**City of Portland, Maine - Building or Use Permit Application**

Location of Construction: 92 Emery St	Owner Name: Marvin Dean W &	Owner Address: 92 Emery St
Business Name:	Contractor Name: Papi & Romano Builders, Inc	Contractor Address: PO Box 1079 Portland
Lessee/Buyer's Name	Phone: 775-2696 x101 <i>for Delaney</i>	Permit Type: Alterations - Dwellings

Past Use: single family	Proposed Use: single family replacement of existing back ell in same footprint	Permit Fee: \$786.00	Cost of Work: \$85,000.00	CEO District: 2
----------------------------	---	-------------------------	------------------------------	--------------------

**Proposed Project Description:**  
Structure will have full basement, kit, bath, master bedroom, laundry and hallway

SI.1

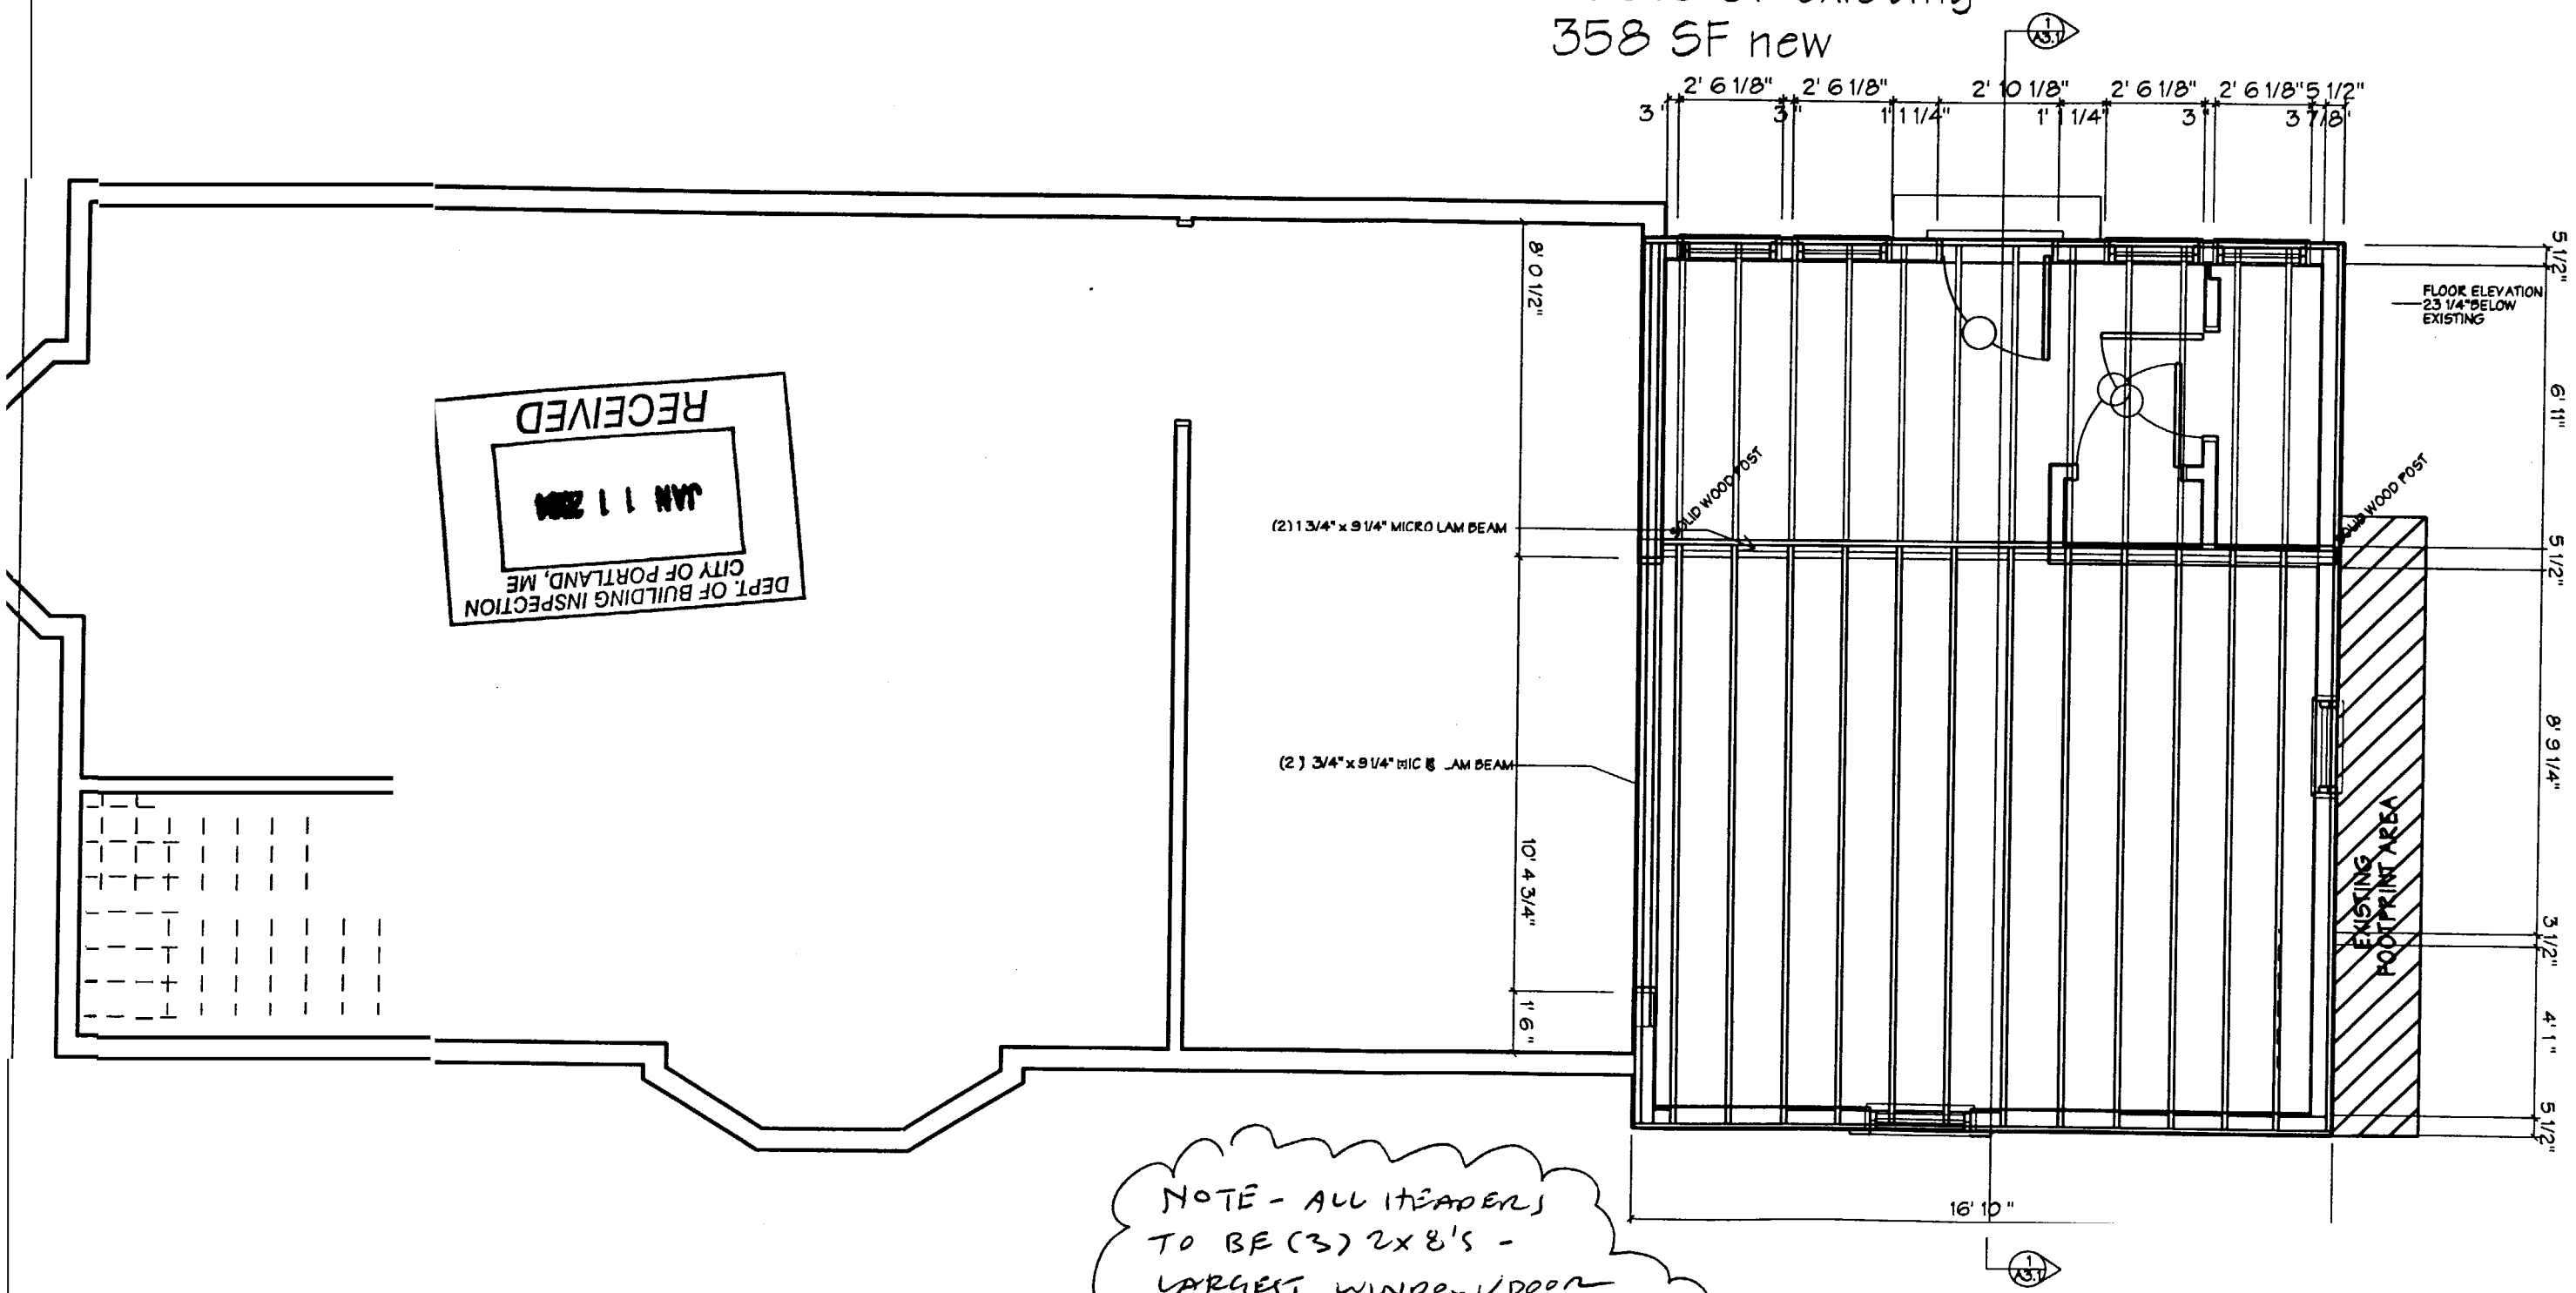
1/7/05-tmm: Joe Delaney submitted new plot plan - ok for zoning - need to address tempered glass issues, need stair details, header schedule, basement details, headroom in basement, and how it is attached to house. - left message for Joe.

1 SECOND FLOOR PLAN
 A1.2
 1/4" = 1' 0"

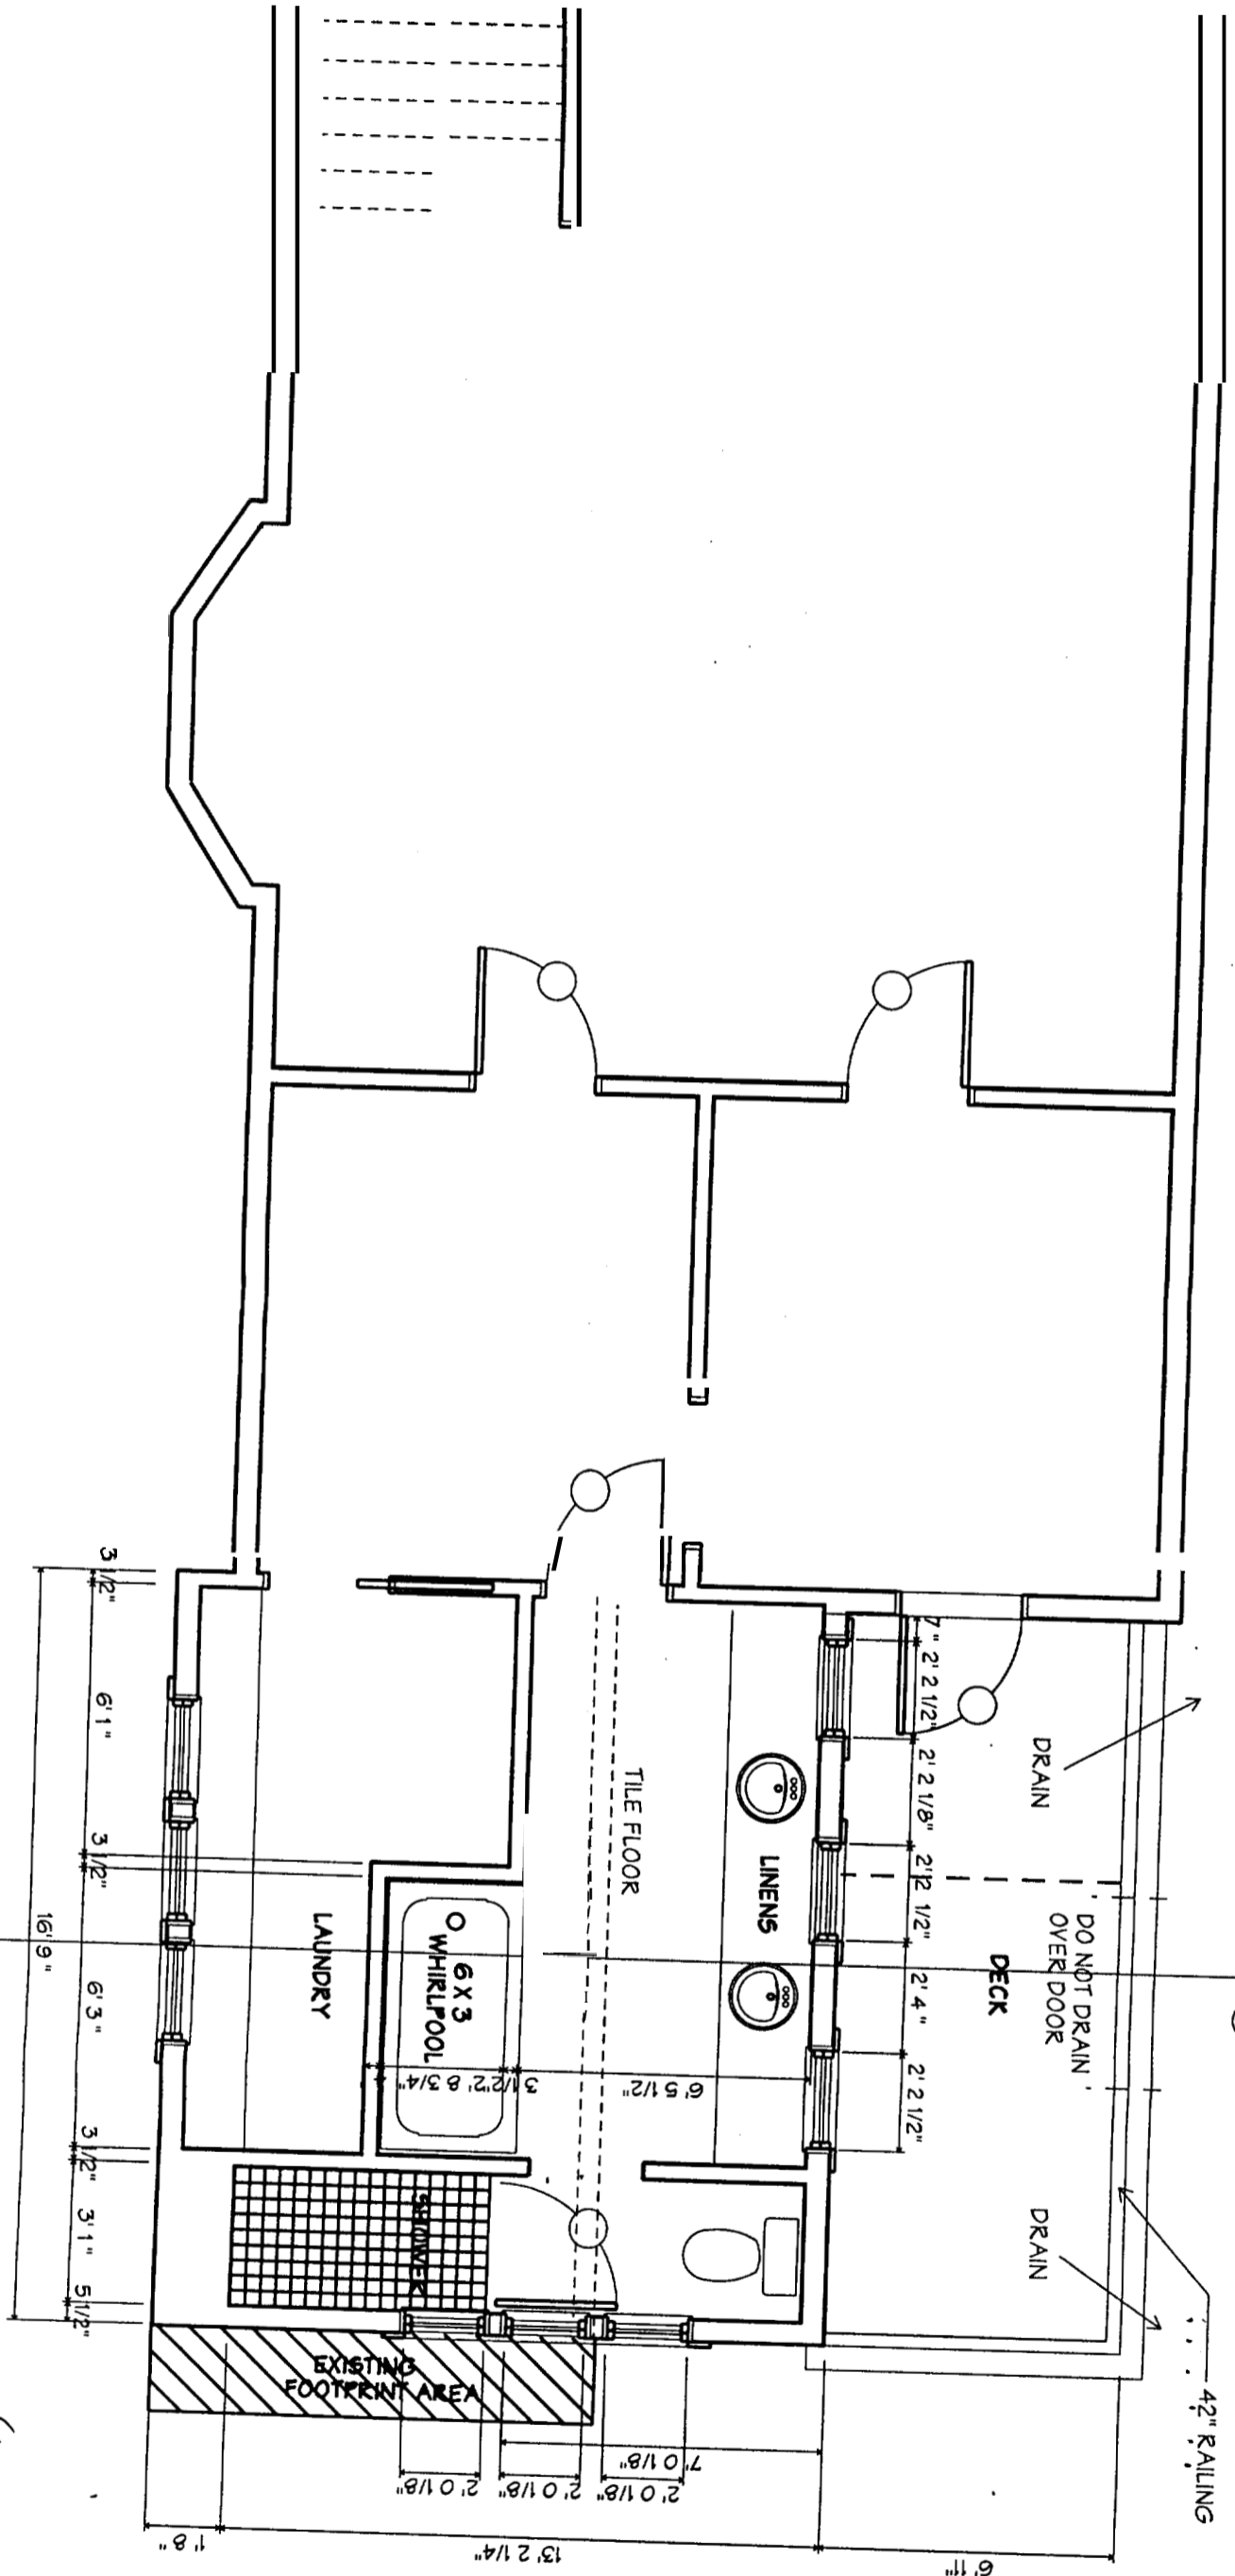
R-6  
2220  
x 50%  
1110 Allowed  
1335 currently - over on lot cov.  
New structure = same lot cov.  
Expanding 2nd flr - OK  
under 14-436B - 80% Allowed  
1068 only expanding 364SF - OK

A2.3

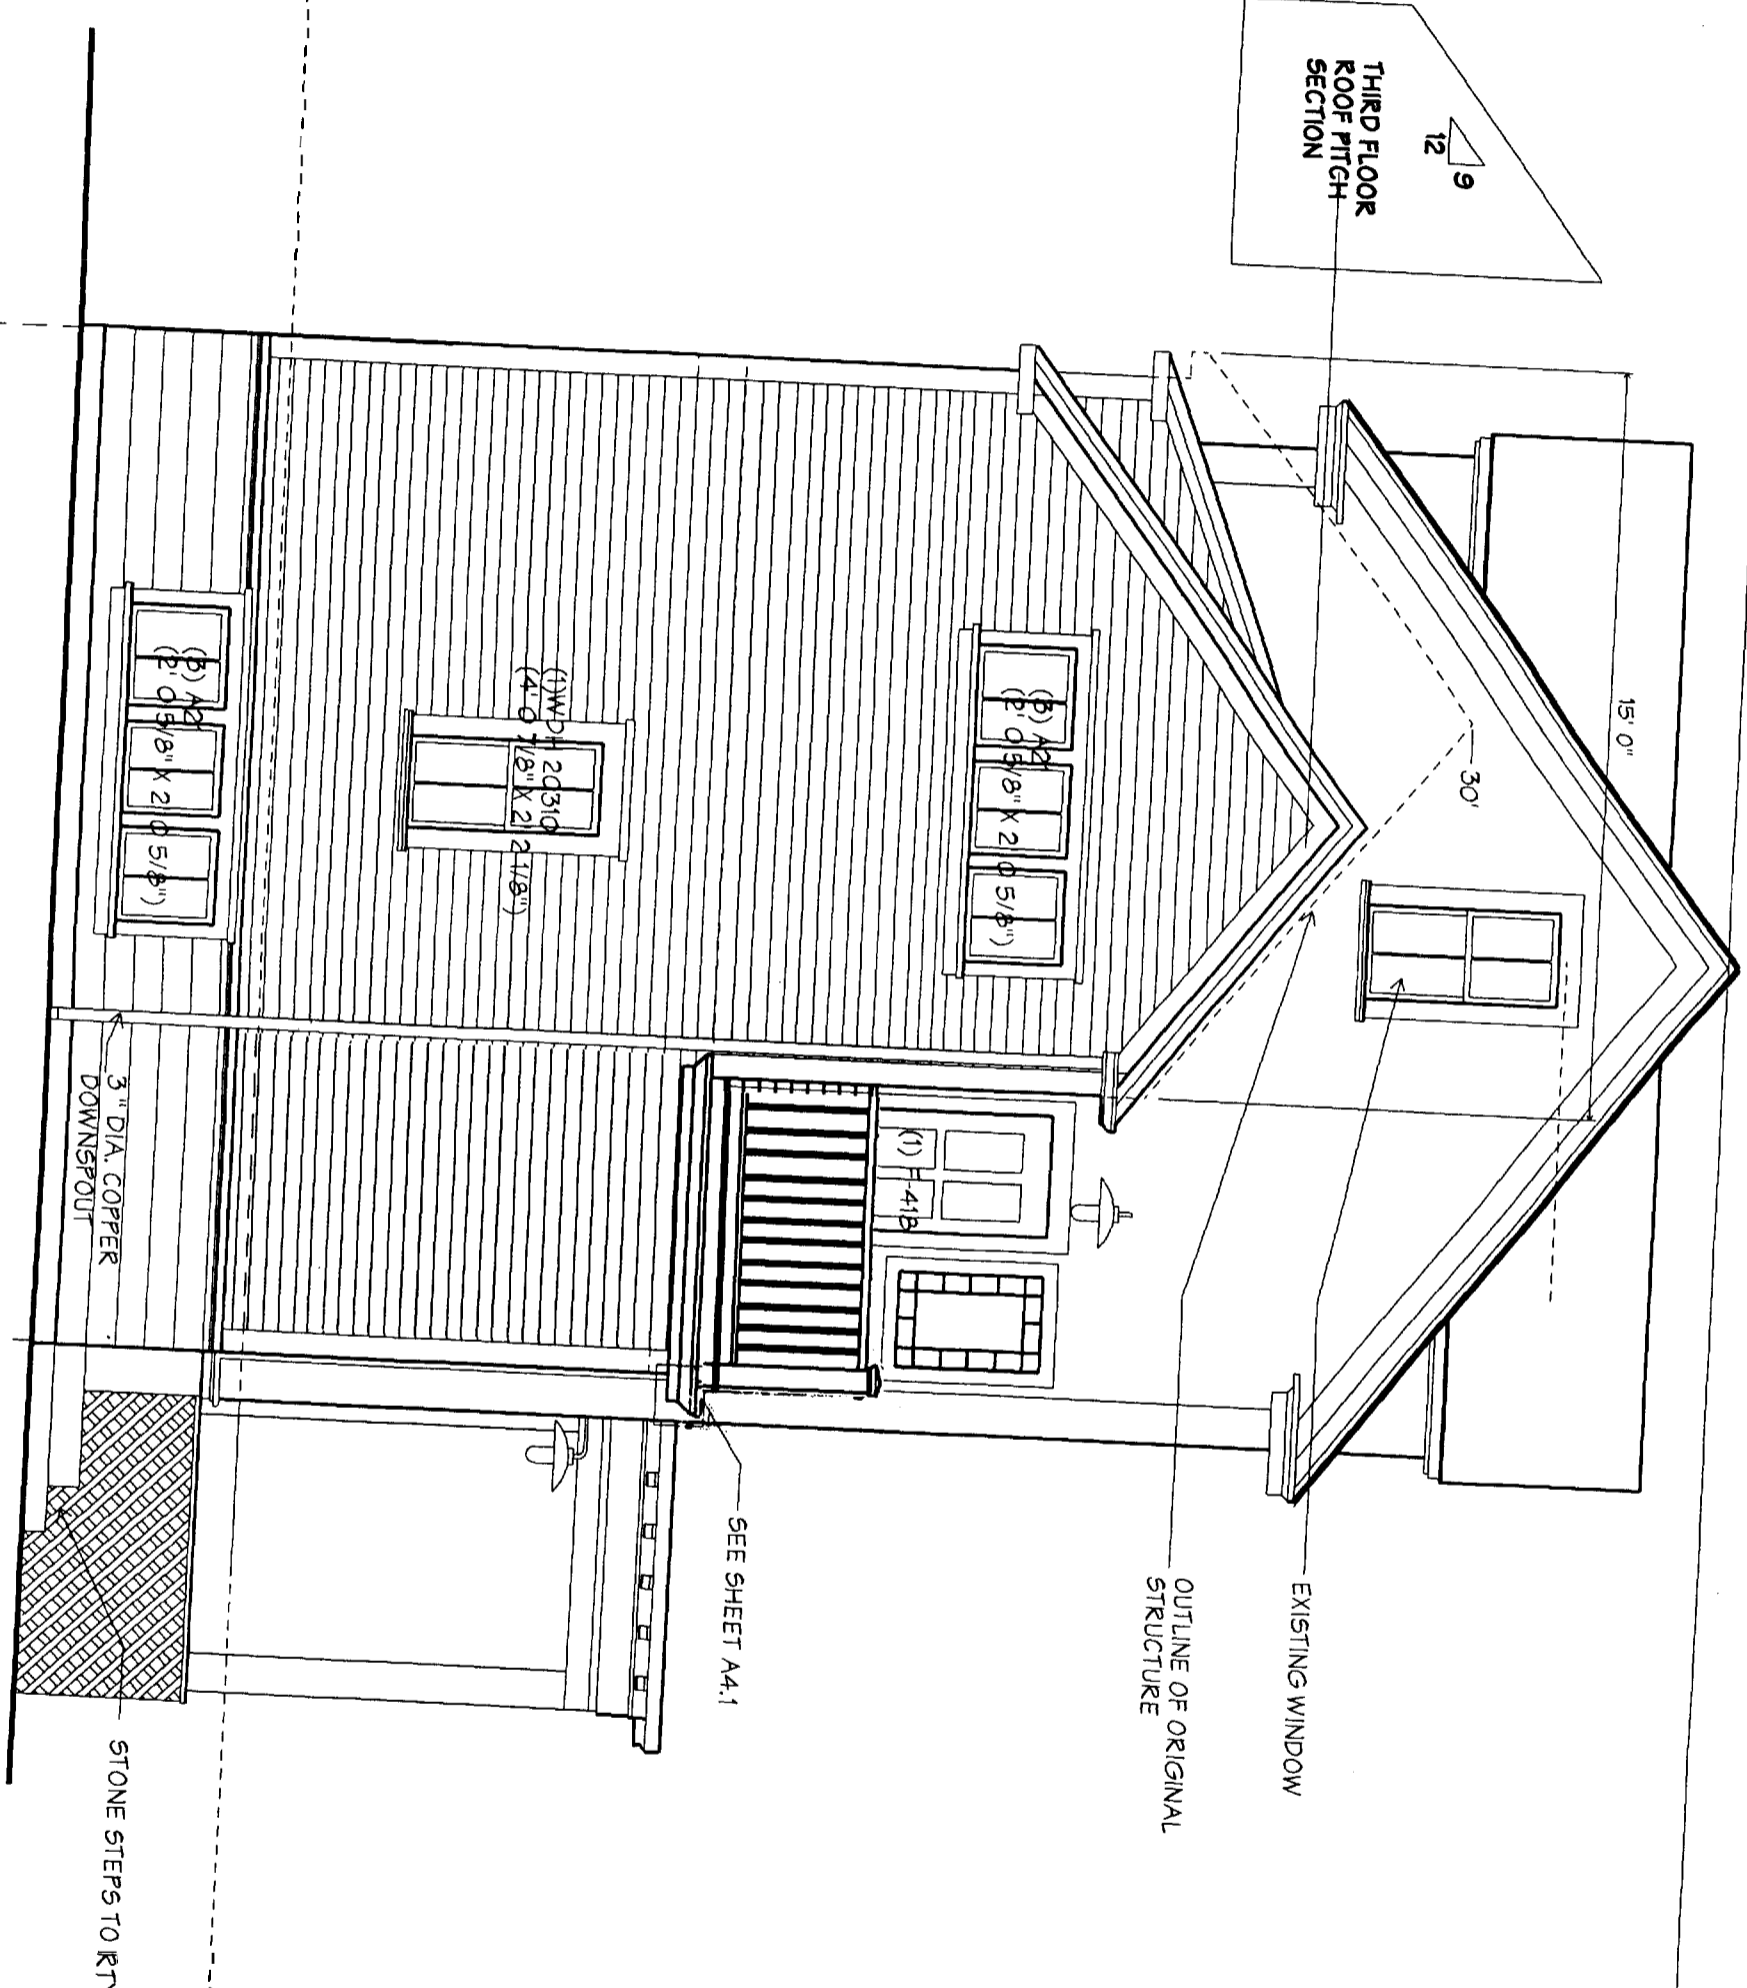
CAN WE KEEP  
THE CENTER UNIT  
+ LOWER WINDOW  
FOR 12.84 S.F. OF  
WINDOW Y?

14.16 for new  
R-302.1?  
OK - Improved  
from existing
